Submission Form

Epping to Thornleigh Third Track Proposal. Application number SSI 5132.

Figure 5.5 Artist's impression of new elevated concourse at Cheltenham Station looking south from The Crescent (indicated circle)

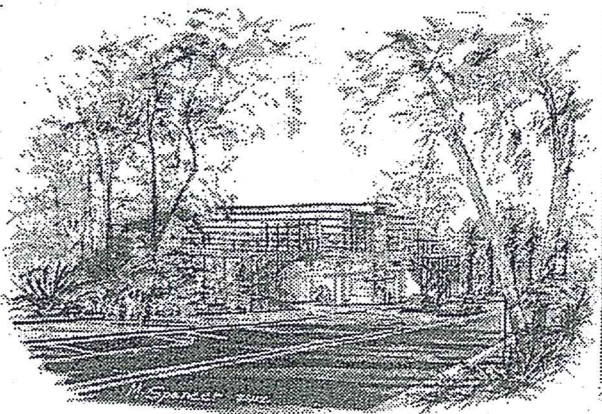
- The proposed redevelopment of Cheltenham Station shows no regard for the HCA. The visual impact of the proposed 13m high glass and steel concourse is totally unacceptable in this HCA.
